Toad Hall Farm
Thurgoland

My Ref: 2022/0713/INVALID
Your Ref:
Date: 21 July 2022
Case Officer: Outer Area
Direct Dial: 01226 772595
E-Mail: developmentmanagement@barnsley.gov.uk

APPLICATION NO: 2022/0713/INVALID
DESCRIPTION: Resubmission of 2022/0105 - Installation of silage clamp and erection of corn store (Prior Approval Agricultural)
LOCATION: Toad Hall Farm, Thurgoland Hall Lane, Thurgoland, Sheffield, S35 7BB

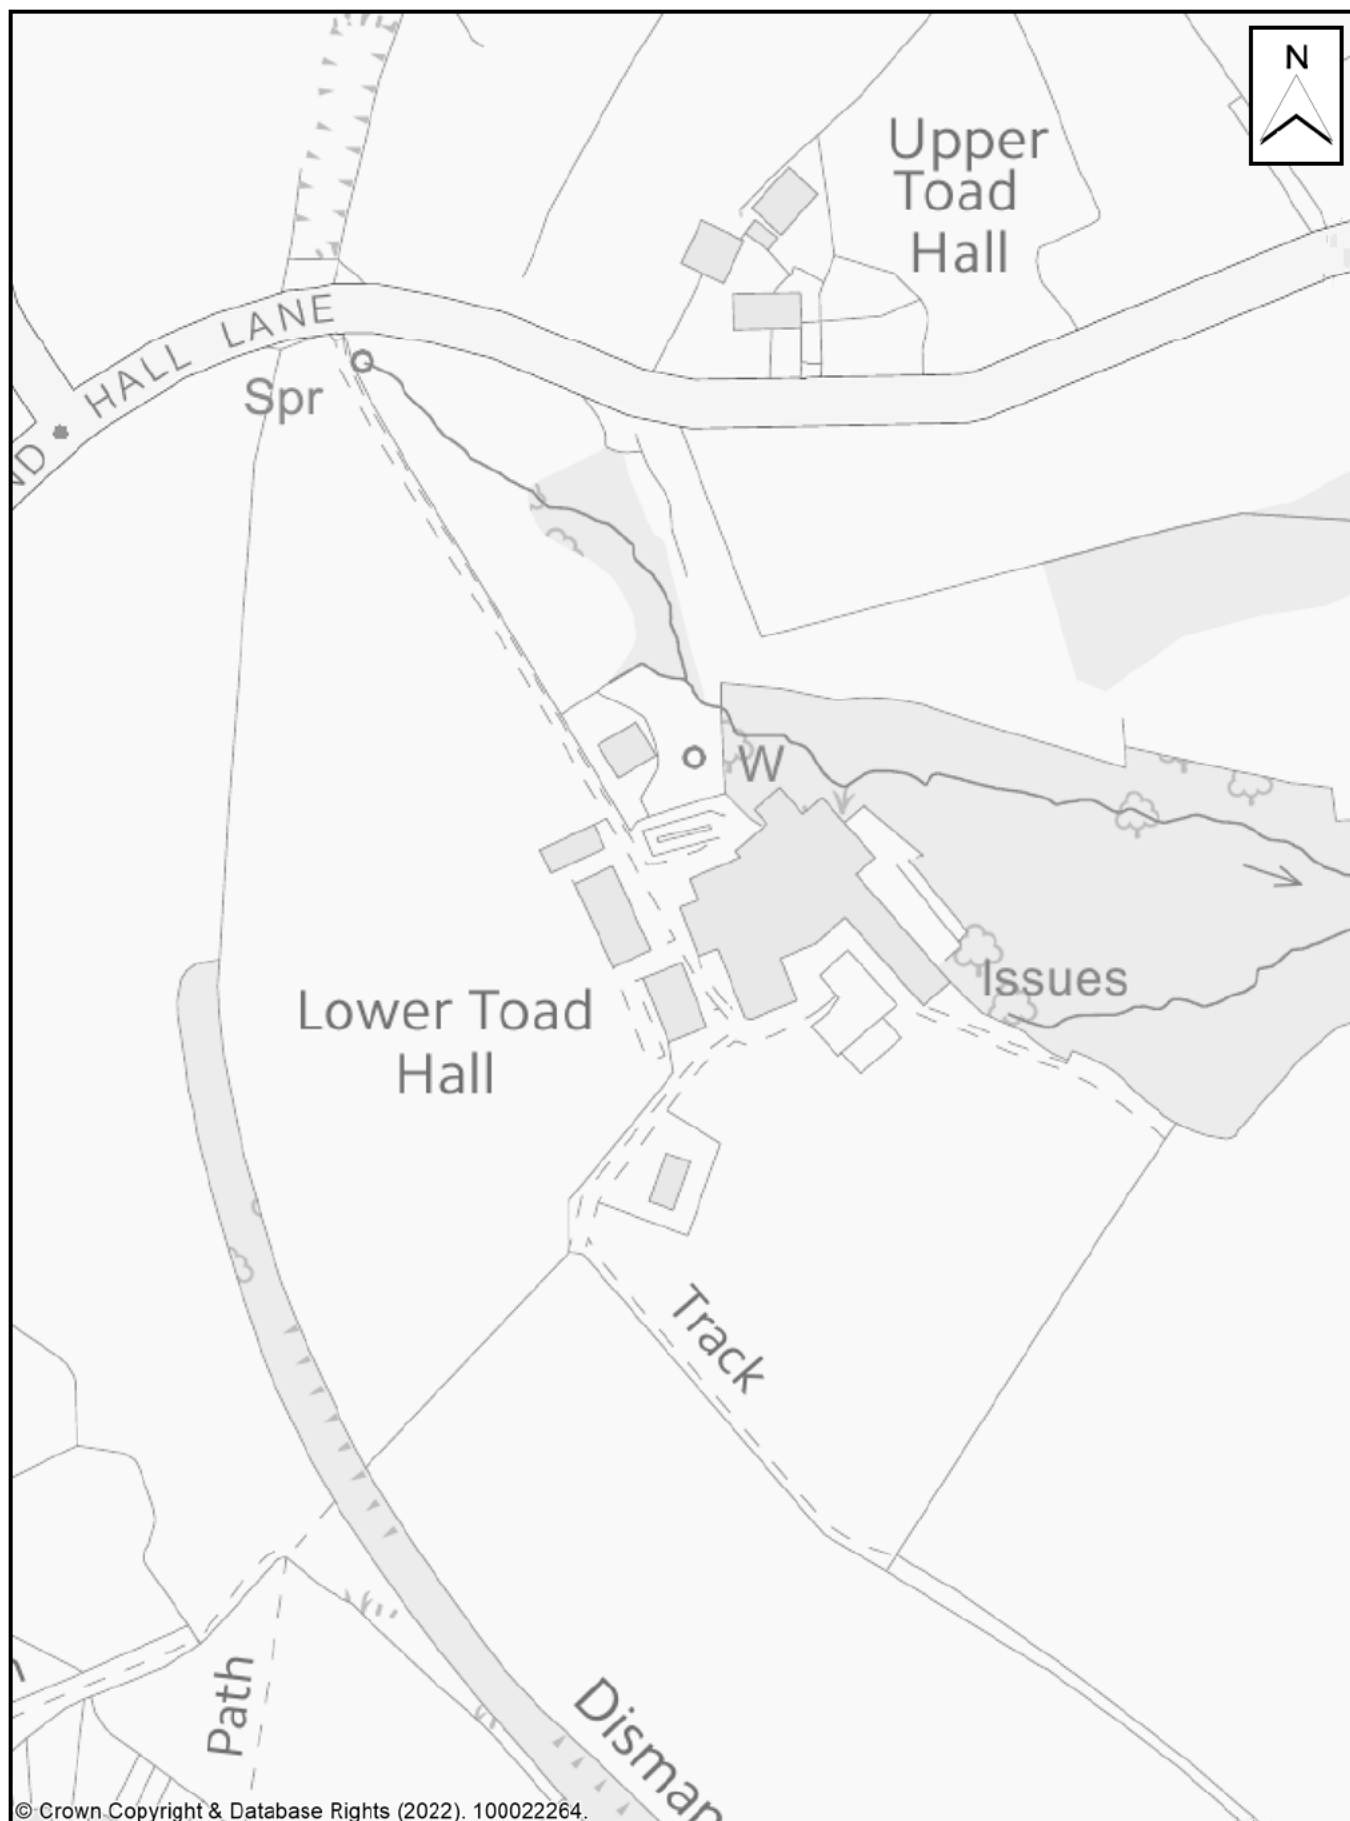
- ③ • On the site plan the 'silage pit' measures at 40m long but the elevation plan drawings indicate the building to be 22.8m long and as such these do not correspond as they should do.

Point ③ New Site Plan included silage clamp/
pit measures 42×15
